Your ref: SSD-10330
File no: MC-19-00005

31 January 2020

SSD-10330 - Data Centre at 17 Roberts Road, Eastern Creek

Blacktown City Council submission to SEARs request for SSD-10330

DRAWN: DATE: SCALE:
 Y 07/04/2020 1:2000@A3
 JOB NUMBER: PHASE: DWG No: REV:
12706 L01 F

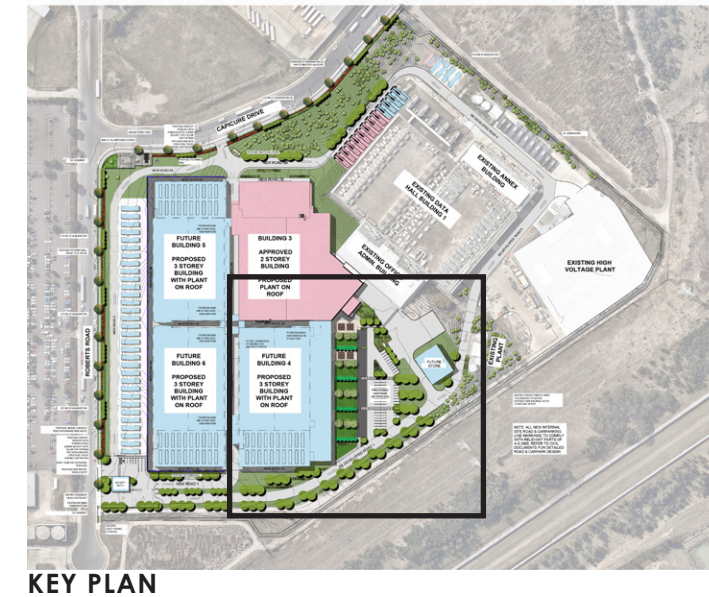
1. The species along the driveway areas are to be changed to provide a species that will provide a larger tree canopy that the proposed *Pyrus calleryana* 'Capital' will not provide. Native larger canopy trees, are preferred, but exotic large canopy trees can also be used.
2. The larger canopy size is required to help offset the canopy cover lost with tree removal for the development. The attached mark-up (at Attachment B) shows the location where larger canopy trees should be included.
3. The car park tree planting locations are suitable, but the species *Elaeocarpus grandis* is to be changed as it does not perform well in this area and is prone to frost damage.
